From: Amanda Scholes on behalf of Planning.Responses
Sent: 22 May 2018 08:32
To: Planning Scanning
Subject: FW: Y/19/18/L and Y/18/18/PL
Attachments: planning objection to garage doors.pdf

Planning Objection, with to Planning and Listed Building Consent
Planning refs. Y/19/18/L and Y/18/18/PL

To:- The Chief Planning Officer
Arun Civic Centre.
Maltravers Rd.
Littlehampton, West Sussex.
BN17 5LF

East Elevation (front)
1:100 @ A3

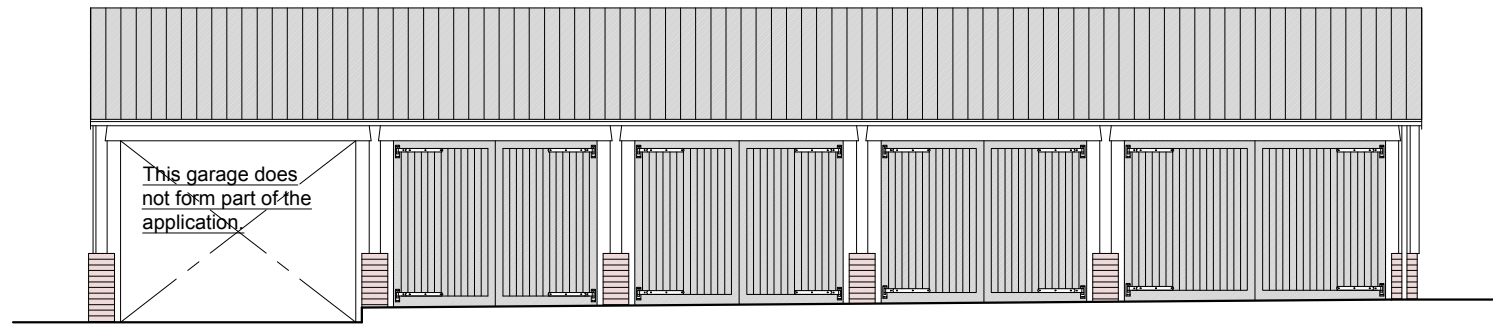
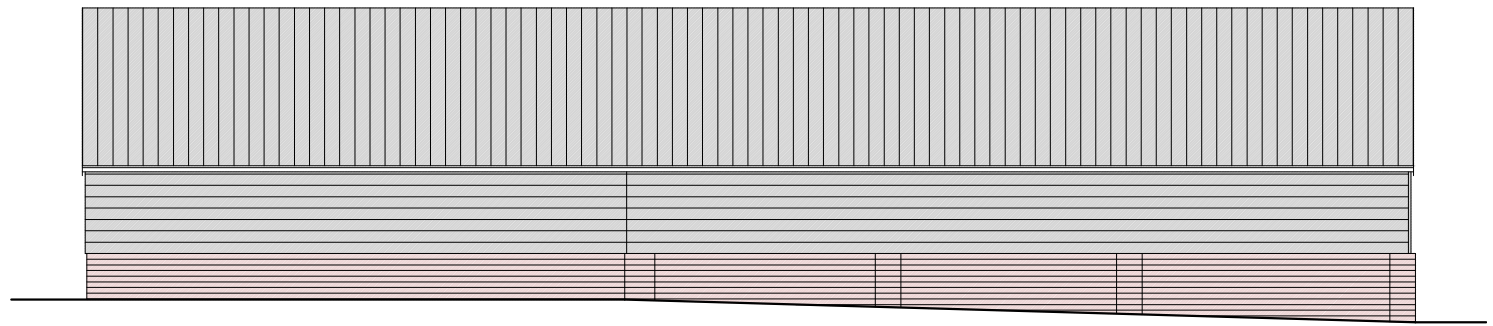
10. The style of doors in the application, have 'visible borders'.

I object on the grounds that *the borders were rejected as being non-compliant* (twice) and was stated as such, both as understood in the initial breach advice by Conservation, and by Compliance advice subsequently, that they must be plain instead (as per the original approved plan).

13 **I object** to the '*over-painting/staining*' of existing doors, as they are currently of a different type of base material to those agreed compliant, and they are already 'treated'. There is no way to be certain how this will adhere to doors already 'treated' and of a substantially different base colour. There is no guarantee that the doors would all look the same as specified, because of this.

Garages Floor plan
1:100 @ A3

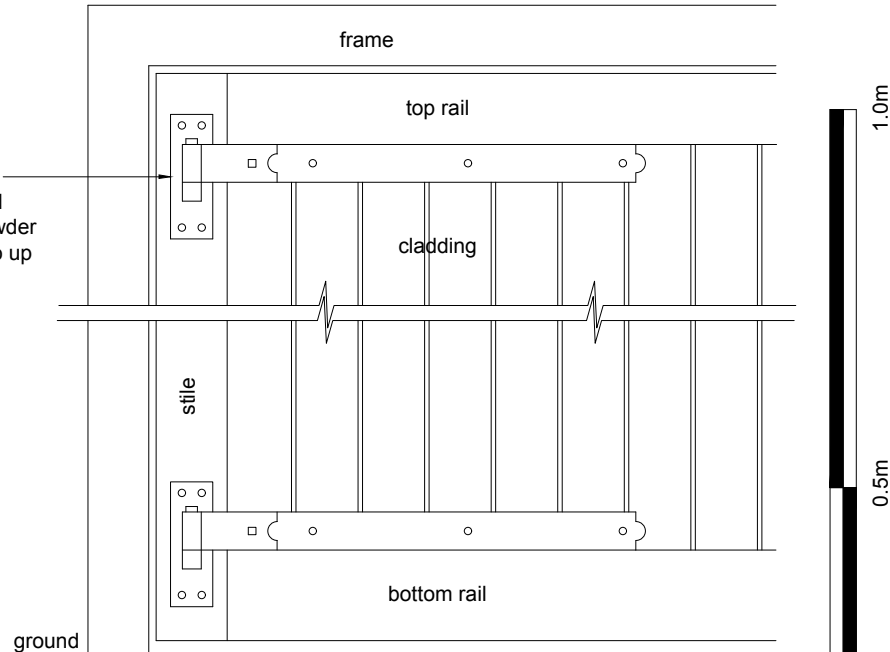
The plan supplied shows car access only in a forward direction, not in relation to reversed parking into the space, in generality, perhaps considered to be easier.

17. The measurements for openings to garages for 2 garages in the application are of apparently similar size.

The third and fourth garages are seen to be 2880 and 3610. The latter being considerably larger than any on the block for ease of access. With a combined total of 6,490, and whereby no wall between the two garages exists, **I object**, on the basis that *this should be more than adequate* to access, to the diagonal if necessary. The garage with wider doors also has additional depth, which is not universal to all garages.
